Development Application and Planning Proposal Review

Authority	Authority's Reference	Agency Concurrence and Referral	Authority Contact	Authority Notification	Submission Due	Submission Made
Parramatta City Council	PP-2022-376	Ref-1344	William Jones	10/05/2022	7/06/2022	7/06/2022

Address	Land Title
241-245 PENNANT HILLS ROAD CARLINGFORD 2118	Lots 1, 2, 5 & 6 DP 805059

To allow a mix of commercial and residential development by permitting a maximum building height of 14m (3 storeys) on the western side of the site and 49m (15 storeys) on the remainder of the site, and permitting a maximum floor space ratio (FSR) of 2.1:1.

Site Plan from Endeavour Energy's G/Net Master Facility Model

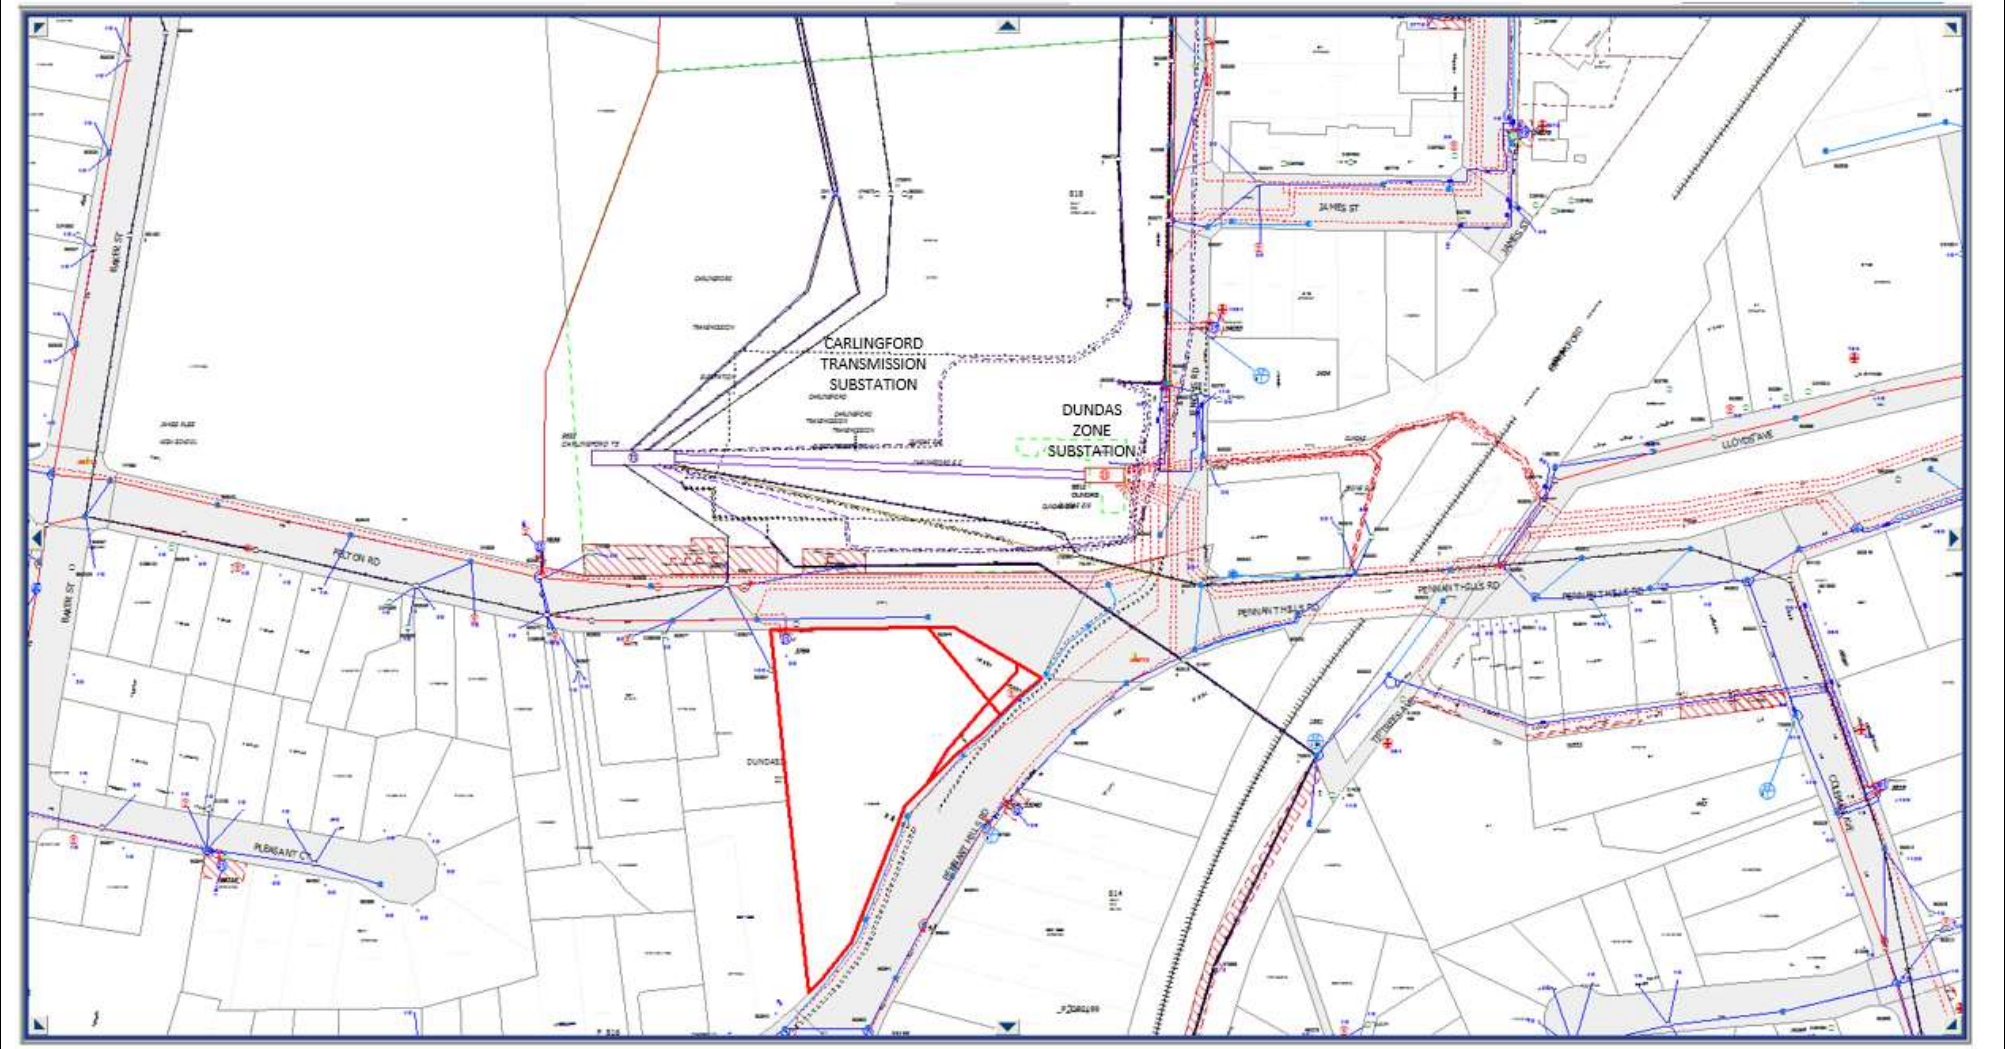
- An easement benefitting Endeavour Energy (indicated by red hatching) for padmount substation no. 3764.
- Low voltage overhead power lines and 11,000 volt / 11 kilovolt (kV) high voltage underground cables to the Felton Road road verge / roadway.
- Low voltage and 11 kV high voltage underground cables and underground pilot cables (carrying protection signals or communications between substations) to the Pennant Hills Road road verge / roadway.
- Endeavour Energy's Carlingford Transmission Substation and Dundas Zone Substation are located at 2-26 Jenkins Road Carlingford (Lots 71-73 DP 815737 and Lot 1 DP 849651) on the opposite side of Felton Road.

- An extension and / or augmentation of the existing local network may be required. Whilst padmount substation no. 3764 located on the site is likely to have some spare capacity, it is not unlimited and may not be sufficient to facilitate the proposed development. The Indicative Architectural Scheme does not appear to show the existing padmount substation or provision for an alternative / new padmount or indoor substation.

Google Maps Street View. Appropriate maintenance of the easement for padmount substation must be done by the land owner to ensure access.
